From: Neville, Julie <Julie.Neville@lancashire.gov.uk>
Sent: 02 April 2025 16:57
To: Planning
Subject: 3/2024/1000 Barn at Greengore Hill Lane Hurst Green BB7 9QT
Attachments: 3 2024 1000 Overlay.pdf

Reference 3/2024/1000
Location Barn at Greengore Hill Lane Hurst Green BB7 9QT
Proposal Change of use of land to form extended residential curtilage and construction of residential storage building. Formation of new vehicular access from Hill Lane for new agricultural building

Proposed Site Plan Scale 1:500

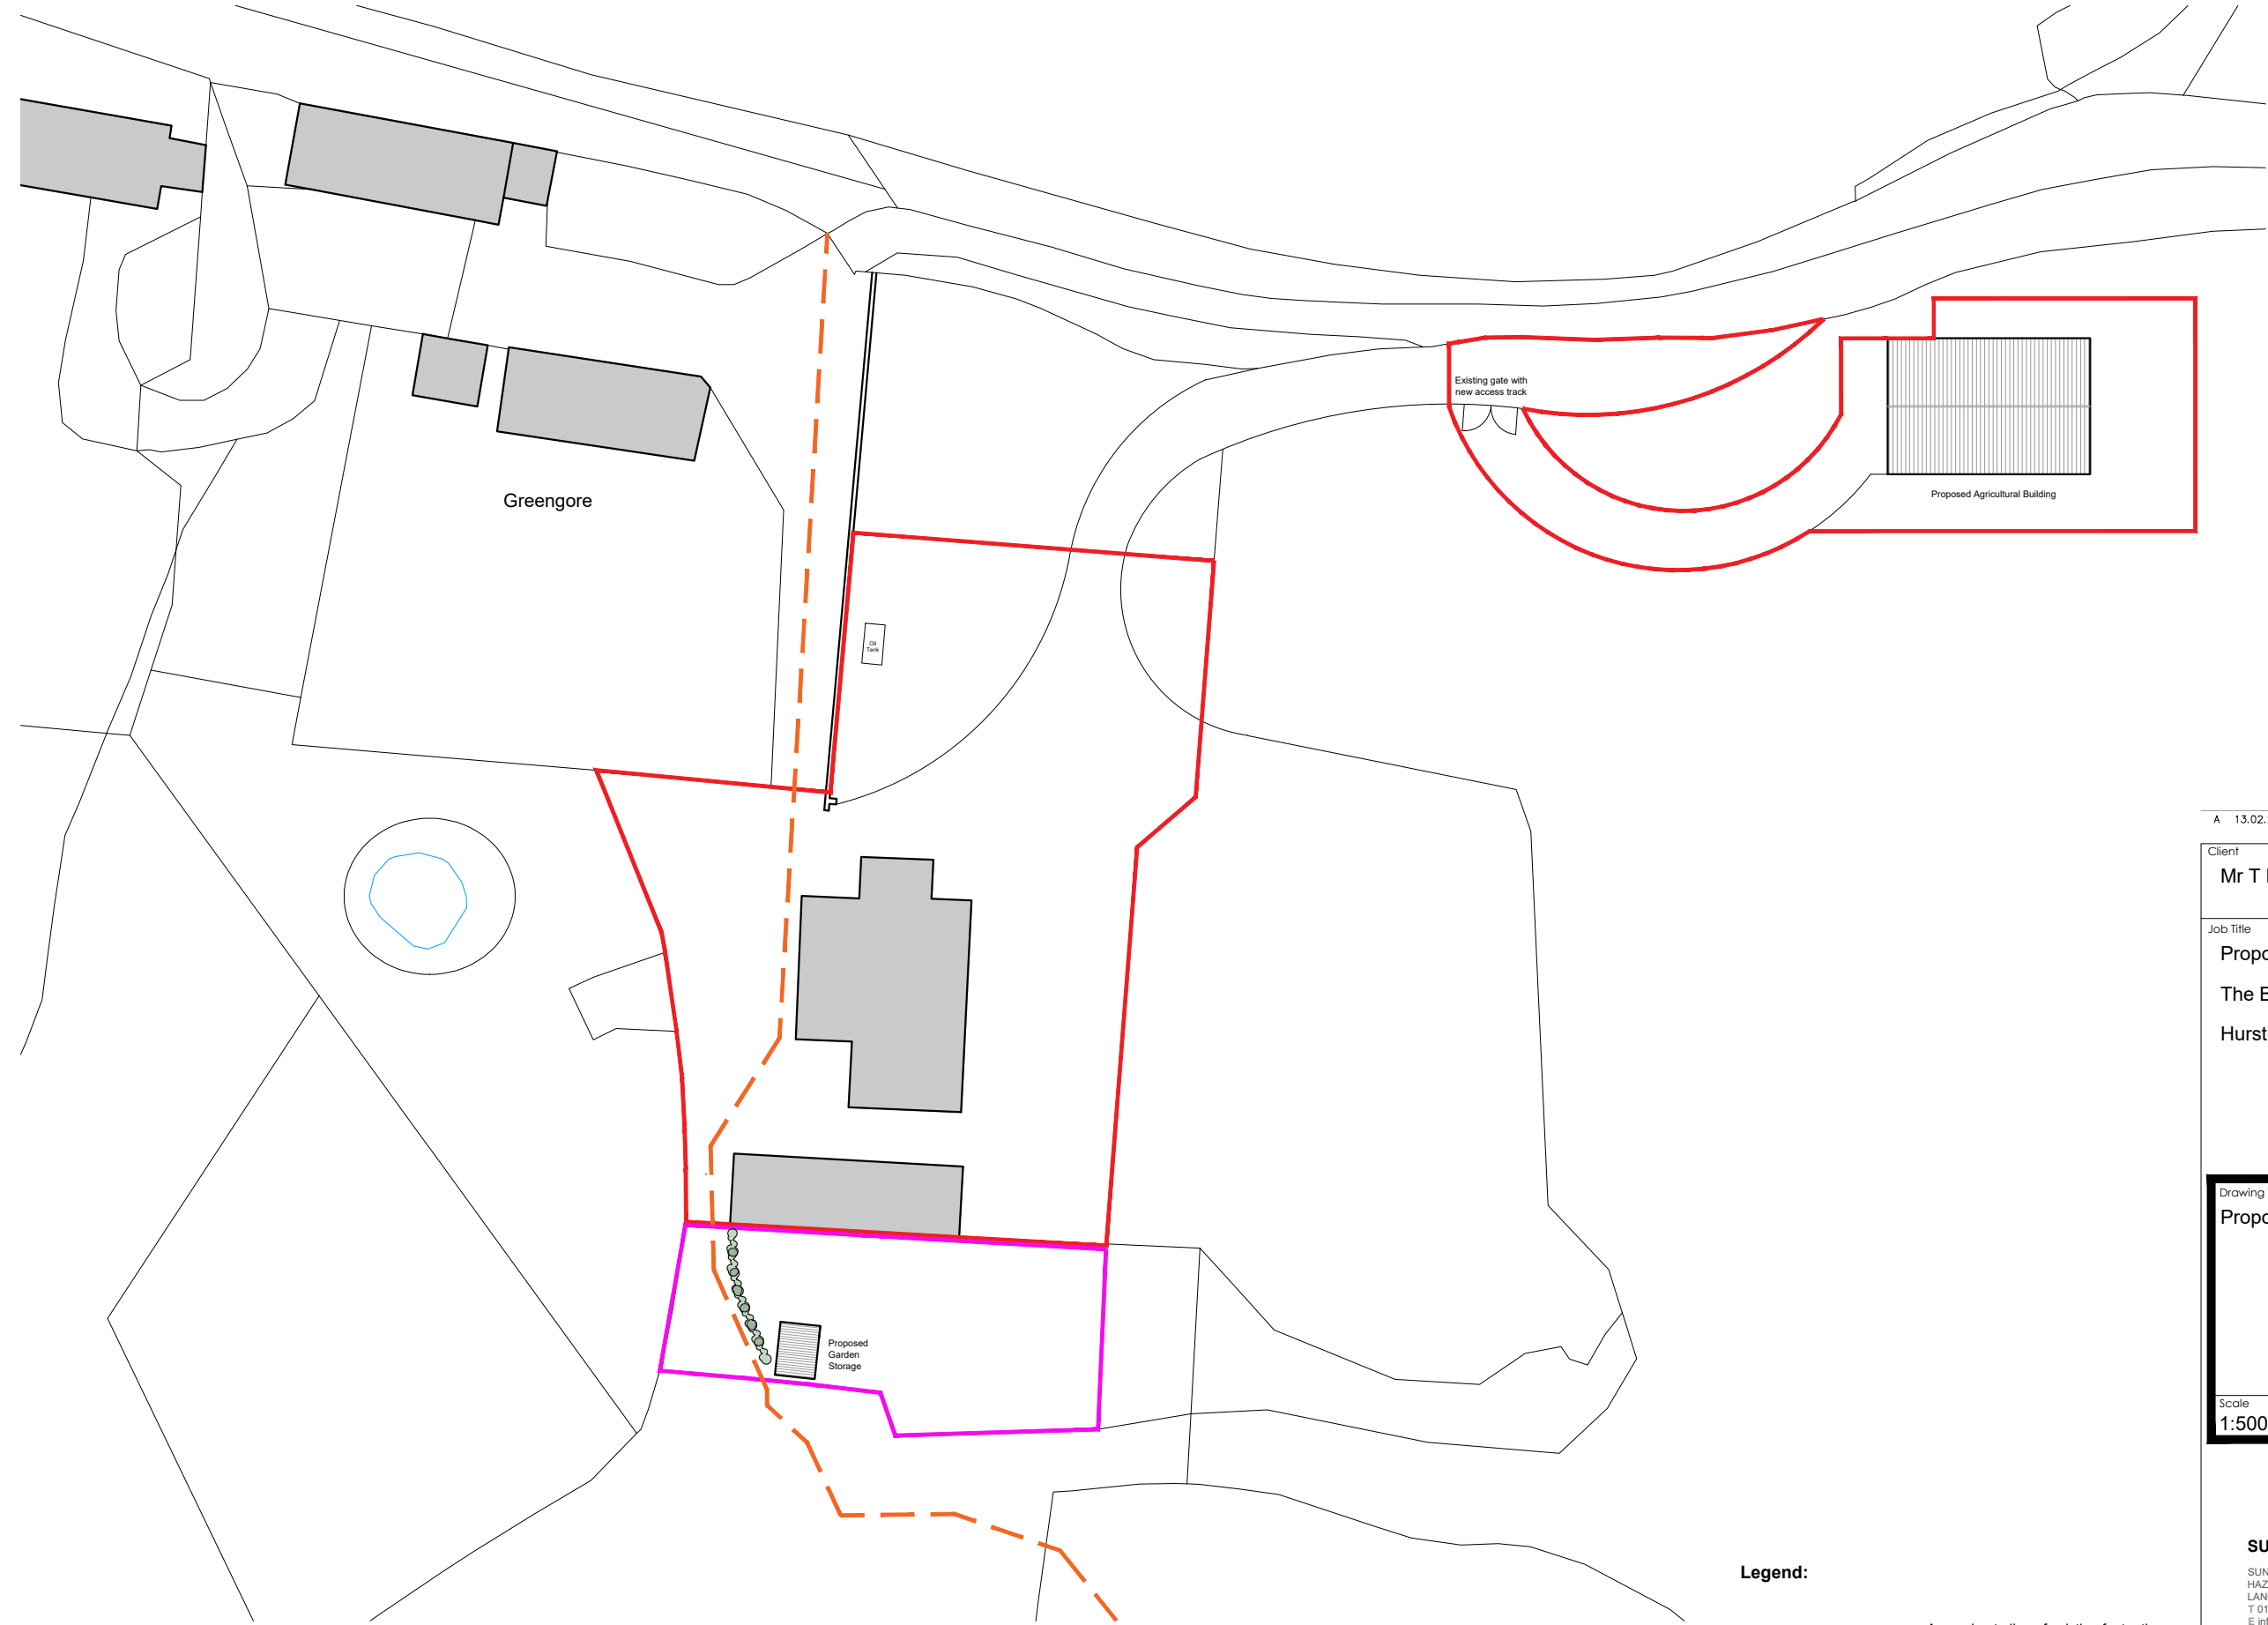
Lancashire County Council Public Rights of Way Team raises no objection to be above application as the development will not cause a significant effect to footpath FP0303017 recorded through the application site, as shown on the attached plan. The infringement or obstruction of the existing public rights would be a criminal offence, as such the right of way should always remain clear, not to be excavated nor used to park or store materials, vehicles or machinery.

Any changes in ground level or installation of drainage should ensure that surface water is not discharged onto a public right of way either within the proposed development site or in close proximity – this is to ensure public rights of way are not exposed to potential flooding or future maintenance issues.

Any trees or bushes should to be at least 3 metres away from a public right of way to prevent any health and safety issues and potential maintenance issues e.g. Overhanging branches or roots coming through the surface of the footpath concerned either within the proposed development or in close proximity.
